Re: SEPA Register 202201448, LP-22-00002

SUBJECT: LP-22-00002 Mohar Farms Preliminary Plat Comments

SUBJECT: WDFW COMMENTS ON LP-22-00002 MOHAR FARM CLUSTER PLAT

RE: LP-22-00002 Mohar Farm

MOHAR FARM PRELIMINARY CLUSTER PLAT

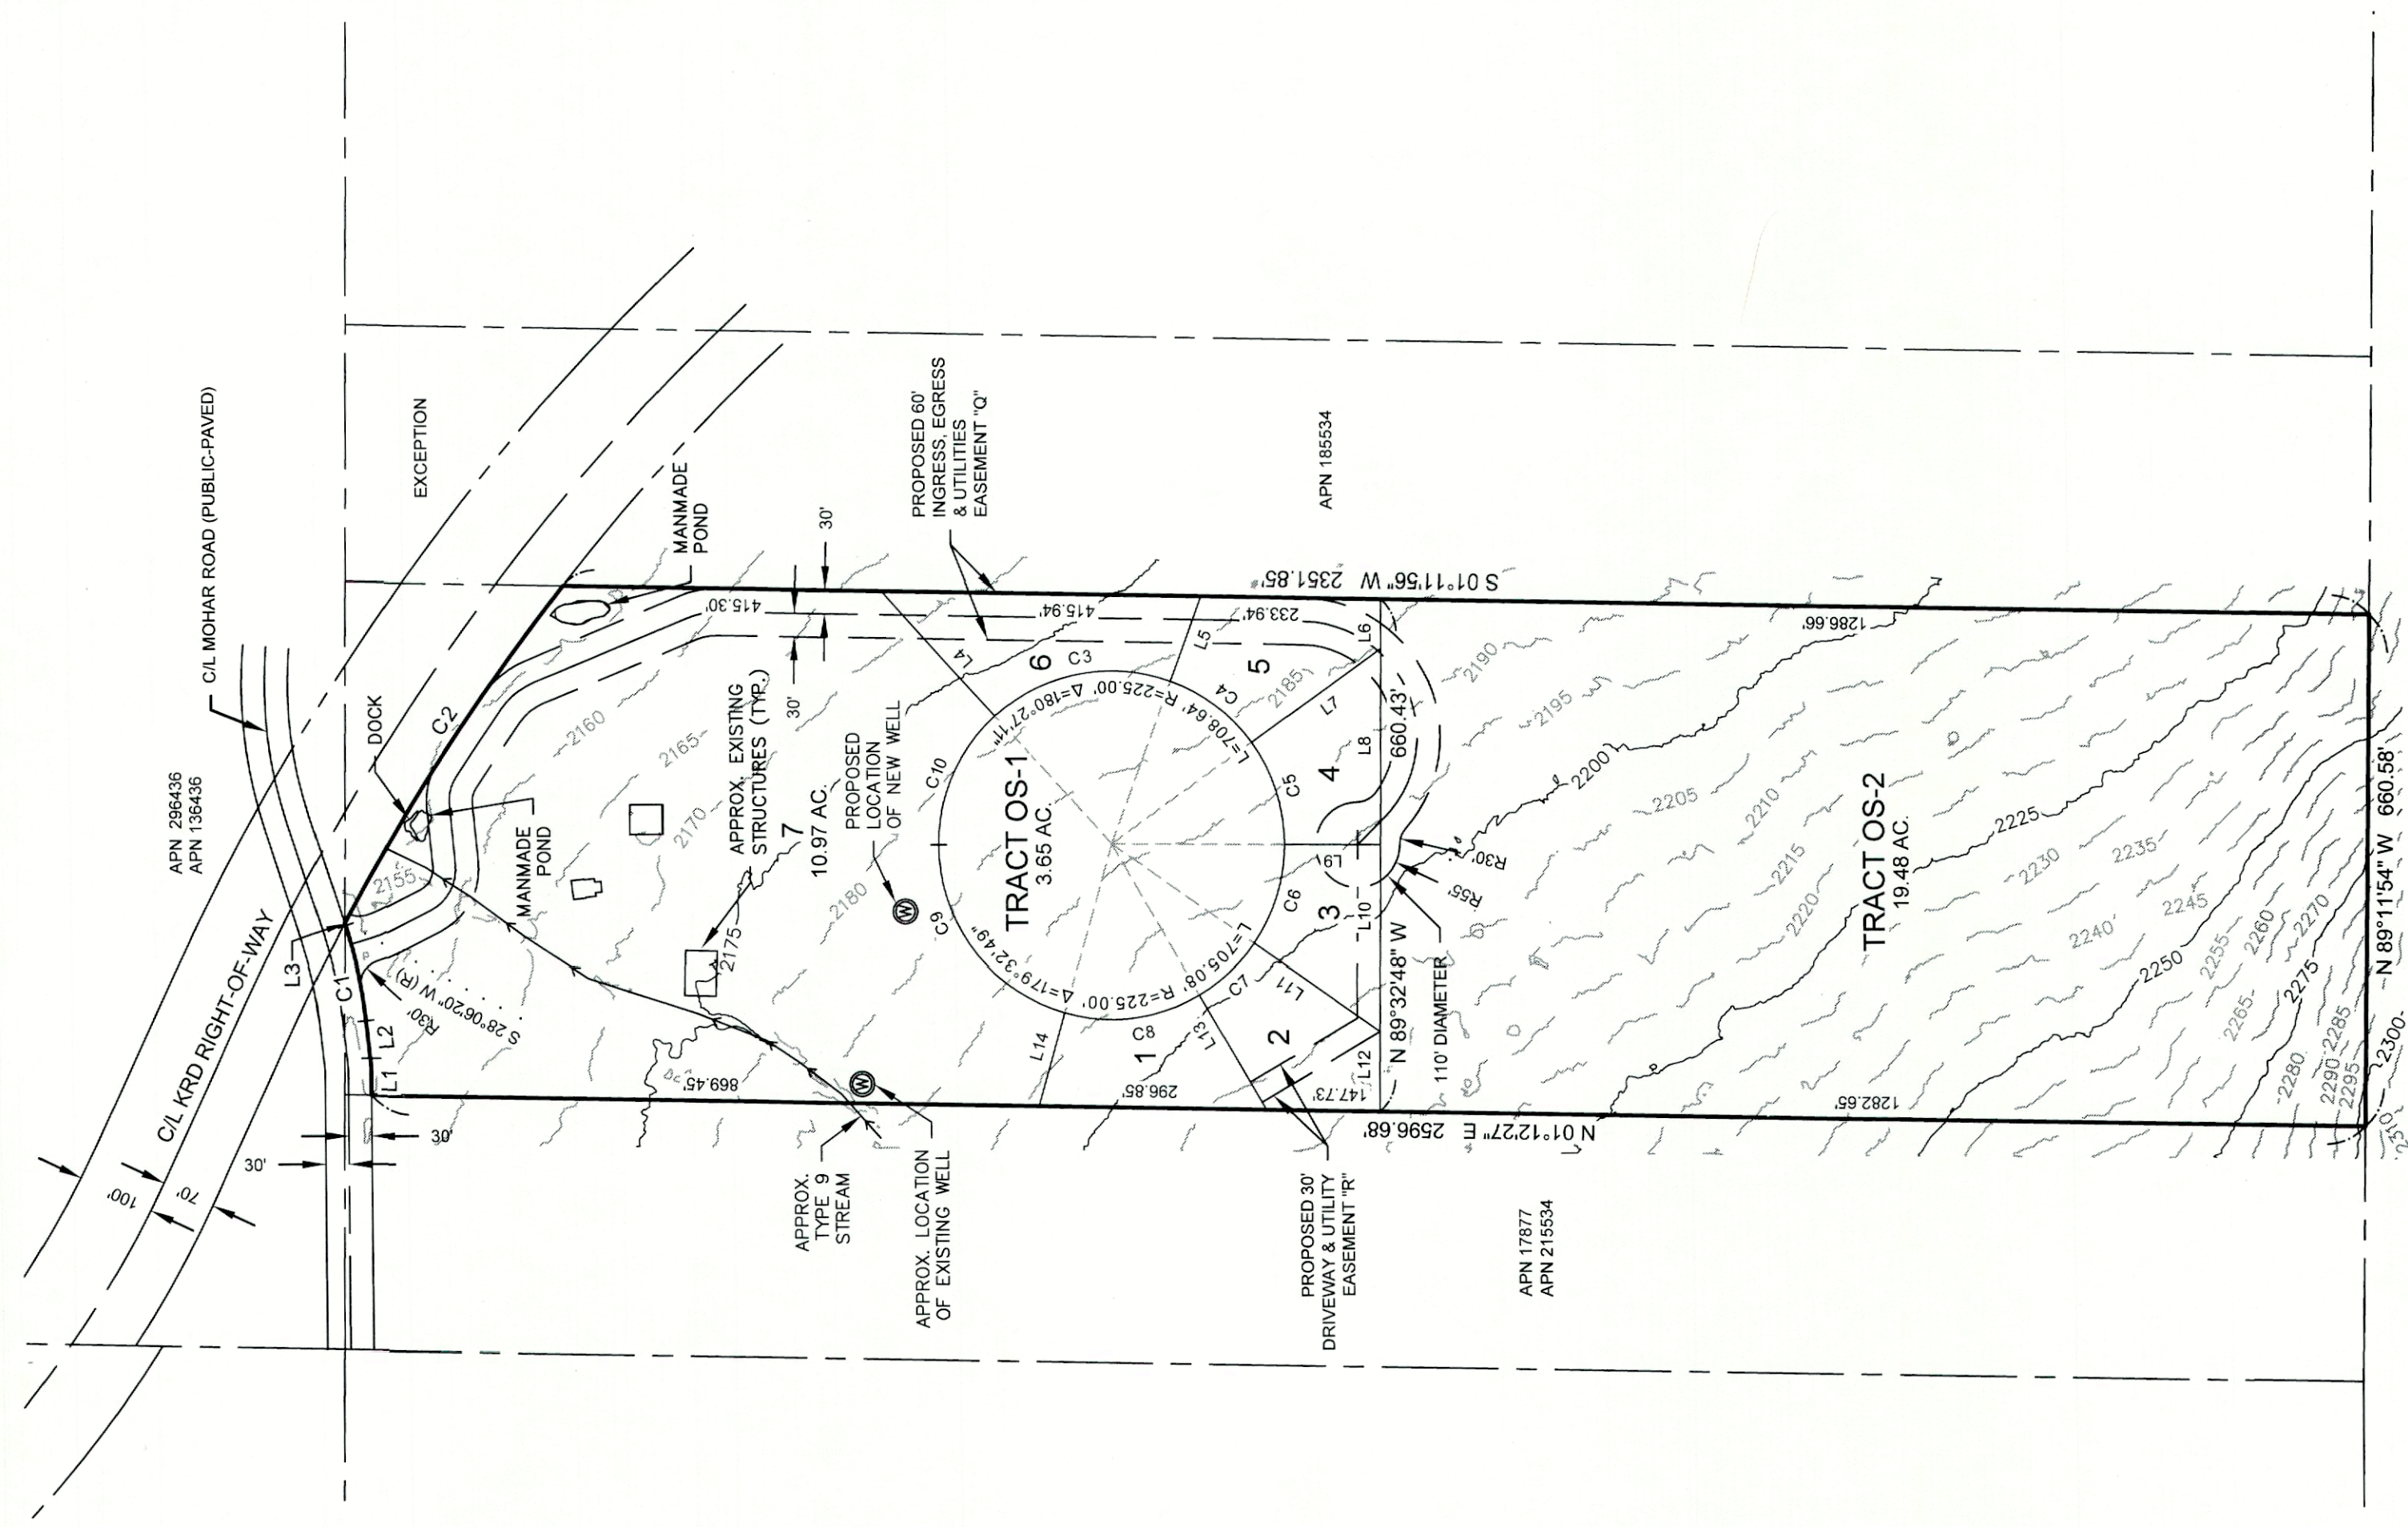
Waterway - Applicant should be aware, as more information is submitted additional permits may be needed to mitigate for the Type 9 stream shown crossing the road easement.

1. Legend will need to be on final plat
2. Basis of Bearing will need to be identified per WAC:332-130-050(1)(b)(iii)
3. Plat should have existing and proposed lot lines shown.
4. Acreage from the existing parcels to the proposed parcels does not match.
